Application for a Non-Material Amendment Following a Grant of Planning Permission

Proposed erection of replacement garage to the rear

23/P/1481/FUH

The proposed garage is to be 300mm longer than approved

170:02B

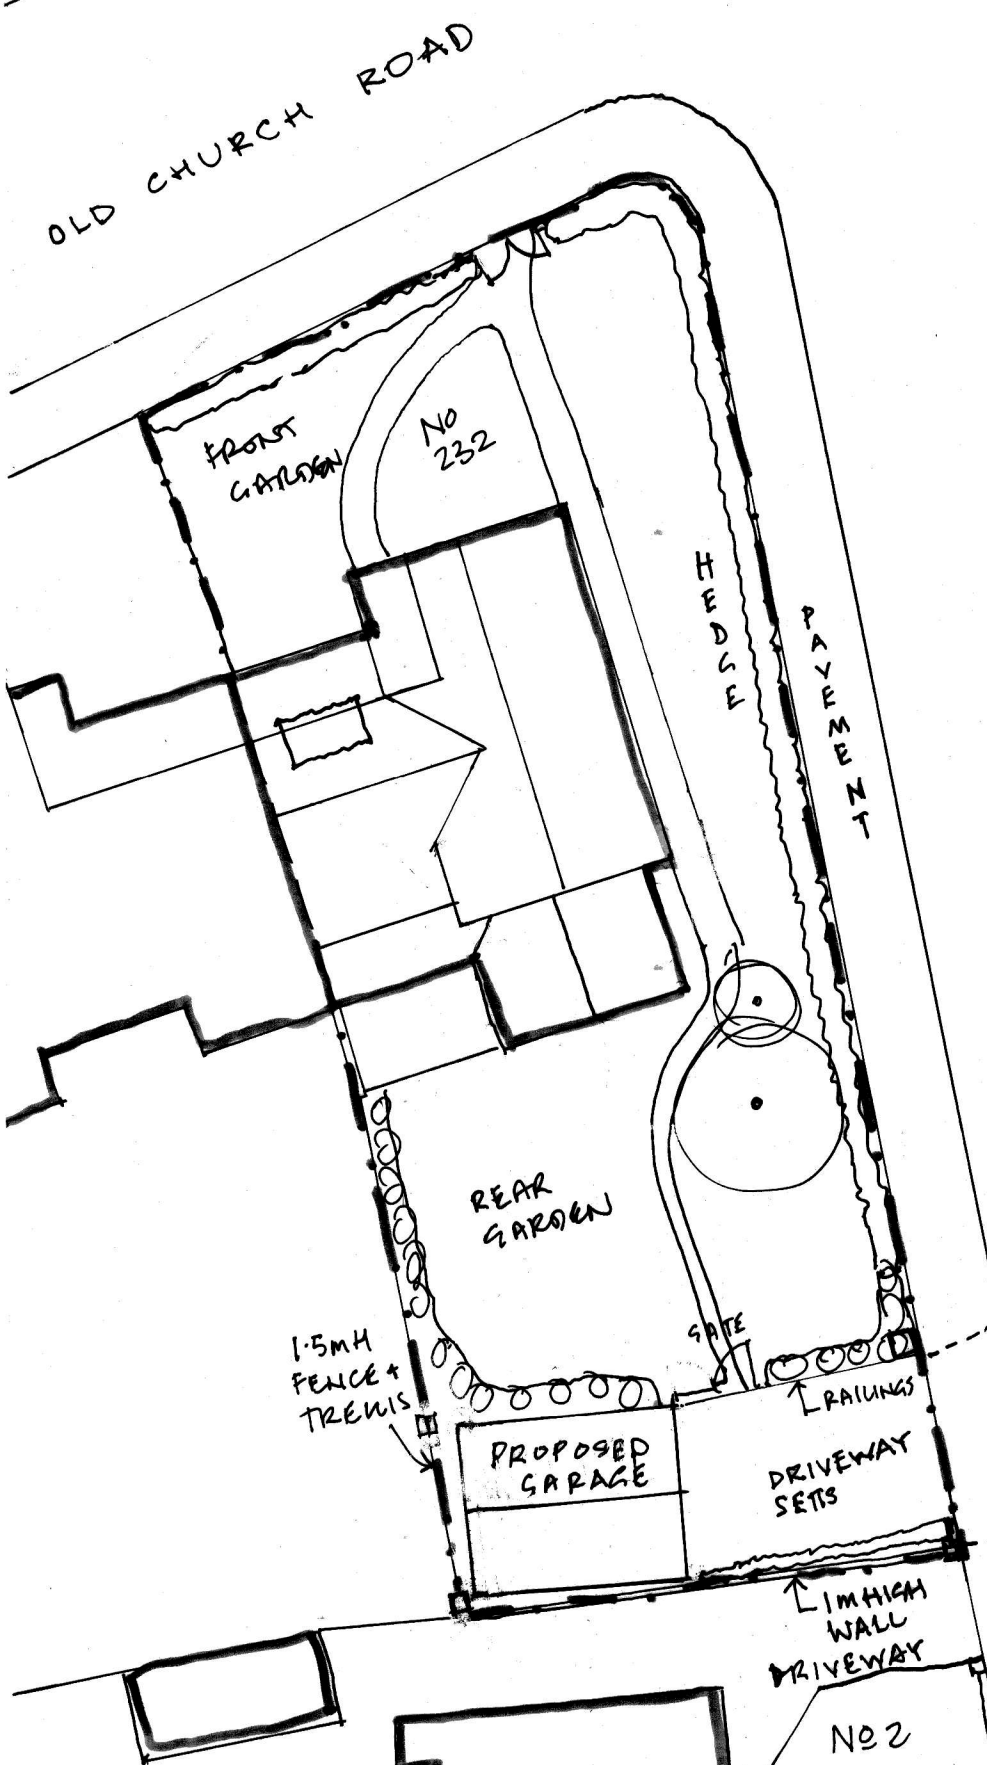
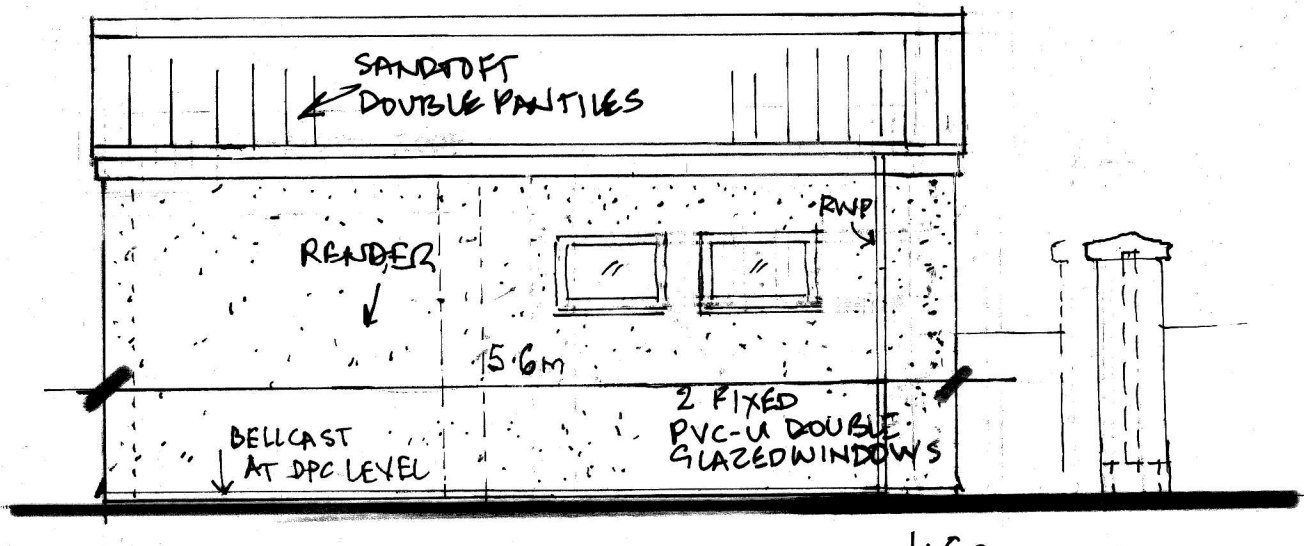
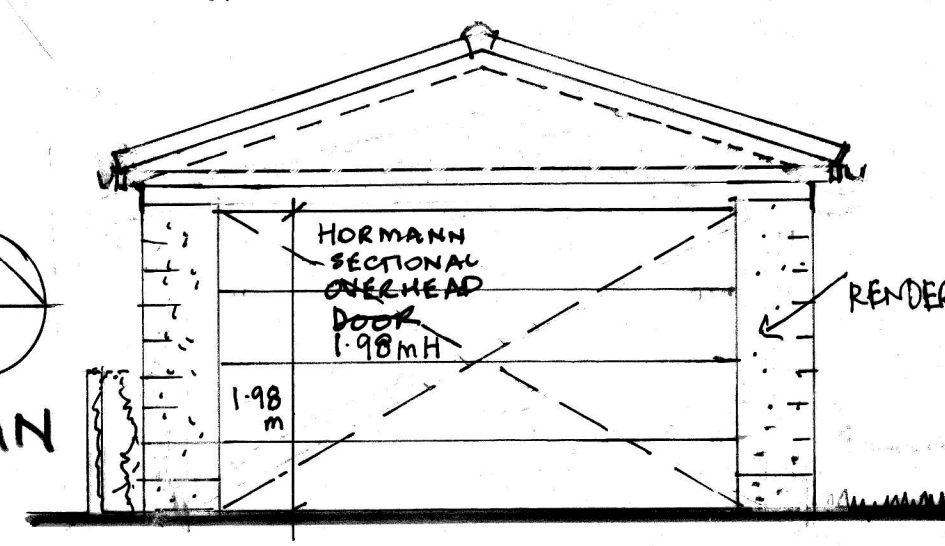
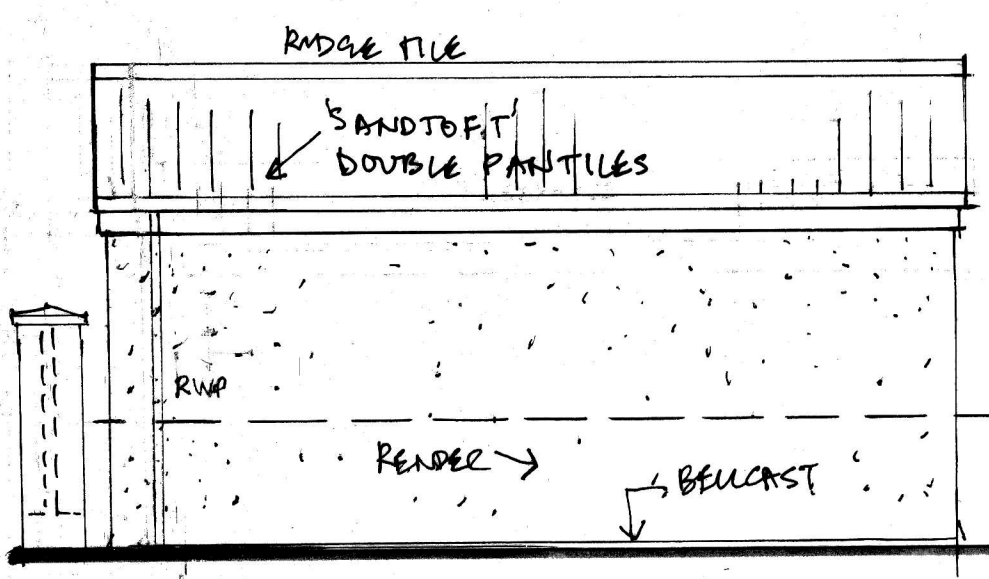
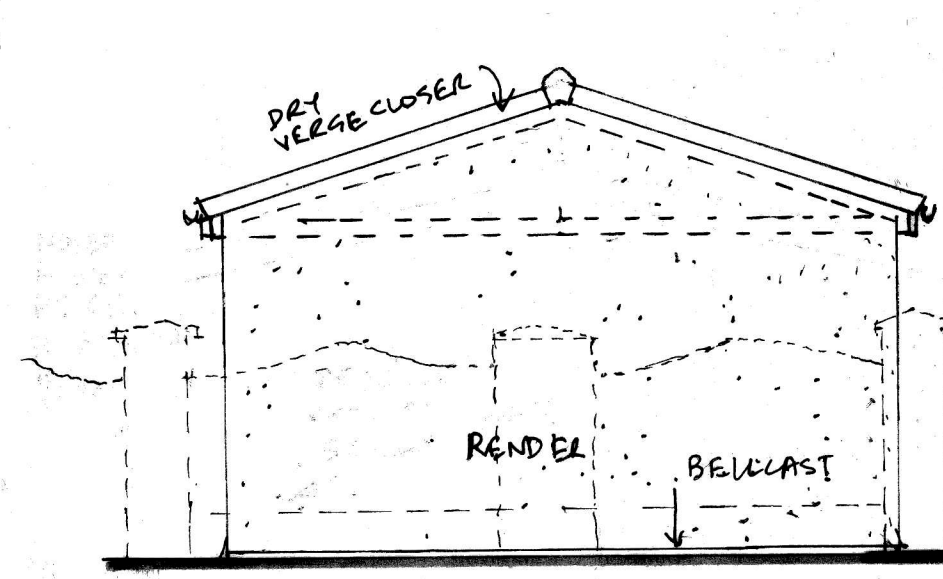
During planning process we stated in correspondence with planning officer that garage would be made shorter by 300mm .
But In error it was made shorter by 600mm
Garage Plan is now shown 300mm shorter
